From: [REDACTED]
Sent: porka986@aol.com
To: 24 May 2013 13:35
Subject: Simon Davis
Re: Application for LDC at 1 & 2, Sidlaw Terrace, Clarence Road, Bognor Regis, West Sussex (Ref. BR/111/13/CLP).

Application for a Certificate of Lawfulness for a Proposed Use – change of use from offices (A2 Financial and Professional Services) to 1 flat (C3 Dwelling Houses) at 1, Sidlaw Terrace, Clarence Road, Bognor Regis, West Sussex.

APPLICATION NUMBER BR/111/13/CLP

Drawn by: P.O'NEILL	Date: NOVEMBER, 2012
Scale/s: 1:50, 1:100, 1:500, 1:2500	
Drg.no 1232 / 02	Rev A

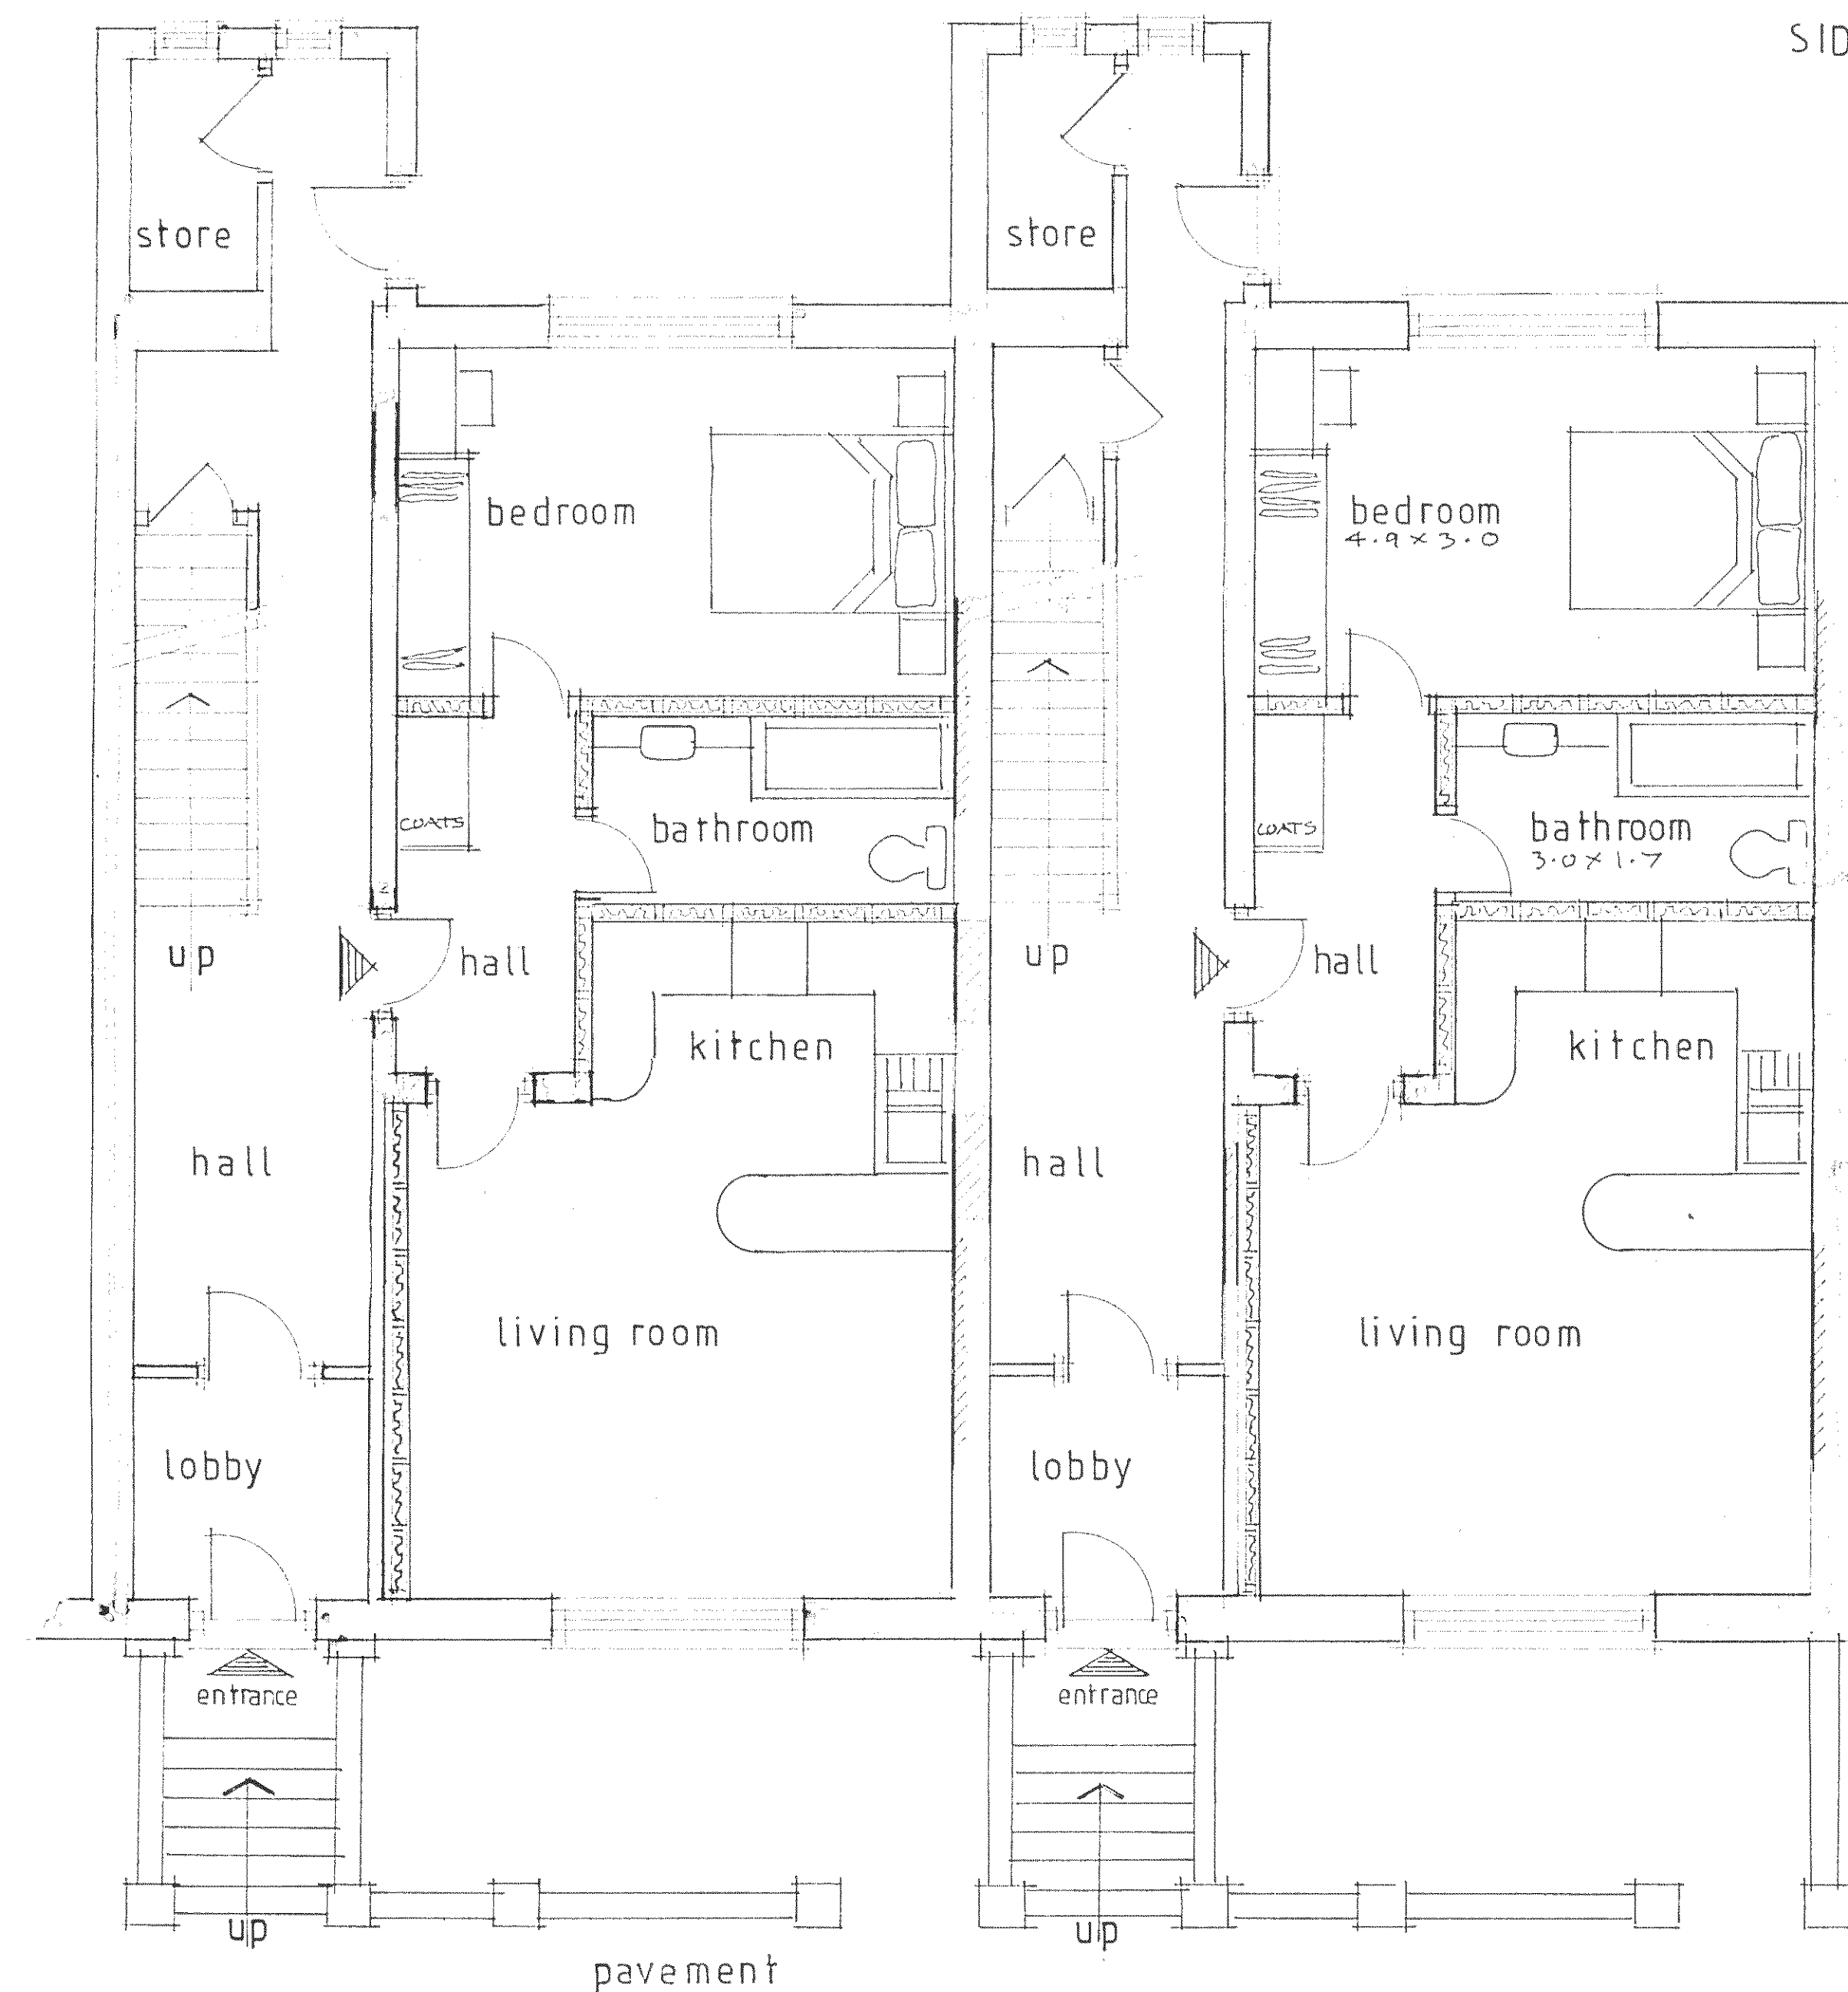
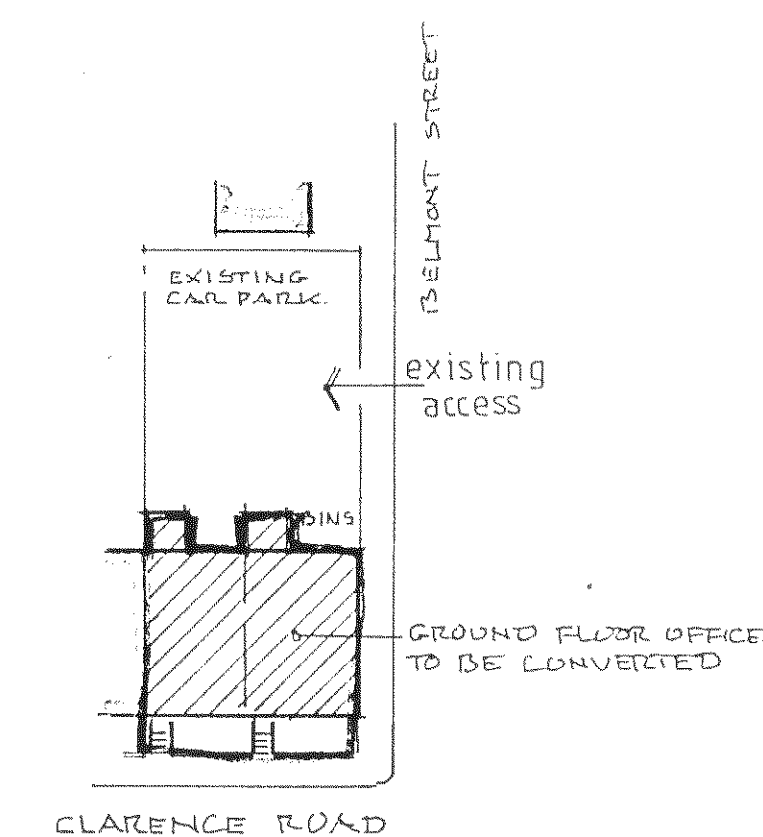
Unfortunately, on the basis that part of the lower ground floor has two flats, I don't think that the proposal represents permitted development. I take this view on the basis of F.1 (a) "some or all of the parts of the building used for any purposes within Class A1 or Class A2, as the case may be, of the Schedule to the Use Classes Order shall be situated on a floor below the part of the building used as a single flat;"

You propose 2 new flats at ground floor level, however, only 1 of these two flats will have an A2 use on the lower ground floor below it, the other would have 2 existing flats below it. I welcome your thoughts on the matter.

Ok if you can submit an amended design proposals plan together with a letter stating that you agree to an amended description such as "Application for a Certificate of Lawfulness for a Proposed Use – change of use from offices (A2 Financial & Professional Uses) to 1 flat (C3 Dwelling Houses)" and also indicate that the address is now 1 or 2 (whichever is the correct number) Sidlaw Terrace

Furthermore, for the avoidance of doubt, I enclose revised drawings annotated to show that the adjoining floorspace previously referred to as No. 2, Sidlaw Terrace remains as shown on the existing ground floor plan (Drwg. No. 1232/01) and no longer forms part of the application.
